Your reference: SSD 7372  
Our reference: EF13/5058, DOC16/318458-01  
Contact: J Goodwin 9995 6838

### **SSD 7237 – O'CONNELL STREET PUBLIC SCHOOL – EIS**

### - ENVIRONMENT PROTECTION AUTHORITY COMMENTS -

#### O'CONNELL STREET PUBLIC SCHOOL

Figure 3: Proposed O'Connell Street Primary School Site in relation to noise-sensitive receivers.

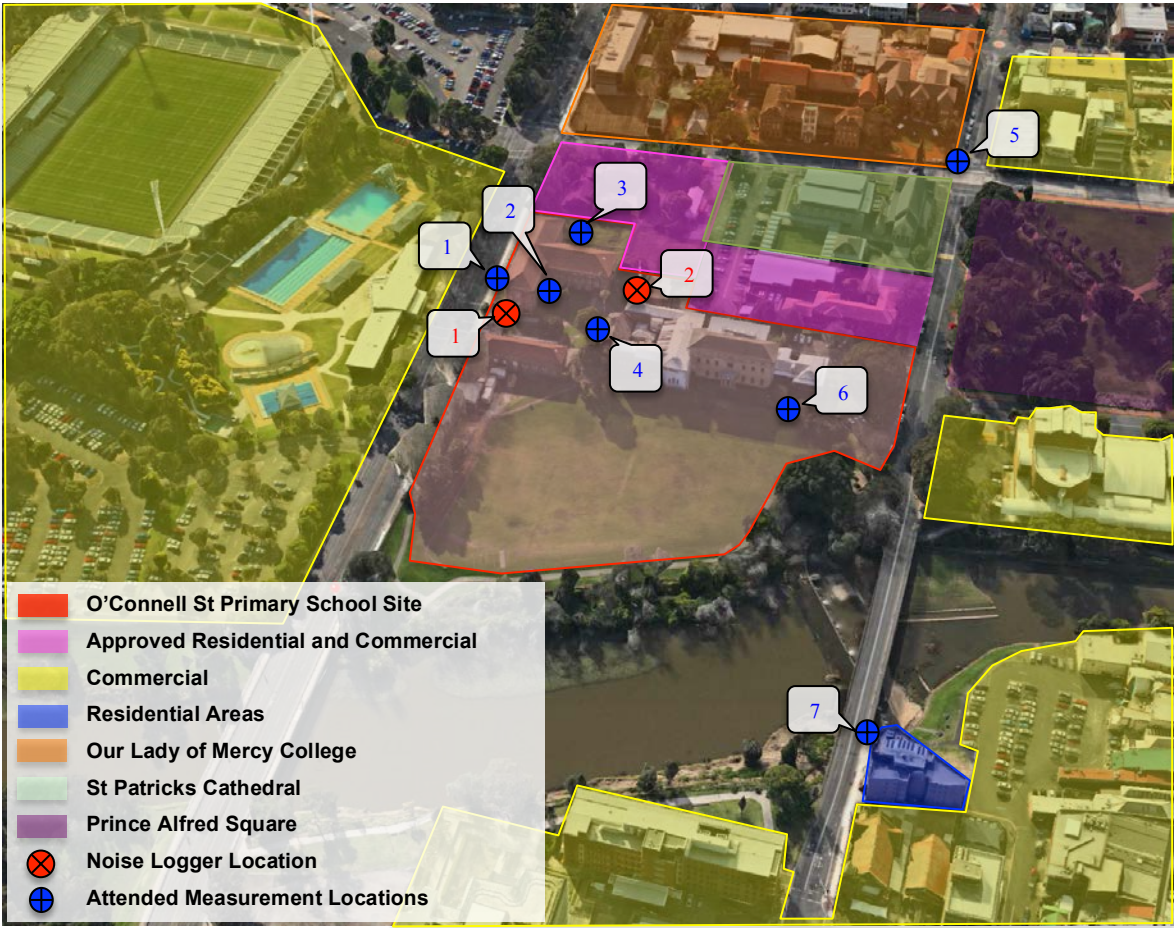
The EPA notes that Figure 3 to EIS Appendix R (Acoustic Assessment) indicates that noise logger location 2 was near the northern boundary of the site (with line of sight to O'Connell Street). The New South Wales Industrial Noise Policy (EPA 2000) generally requires background noise monitoring to be undertaken at the nearest sensitive receiver, rather than the site of the proposed development. However, in this case the EPA accepts that the location of logger 2 is likely to provide data representative of background noise levels at the nearest sensitive receivers.
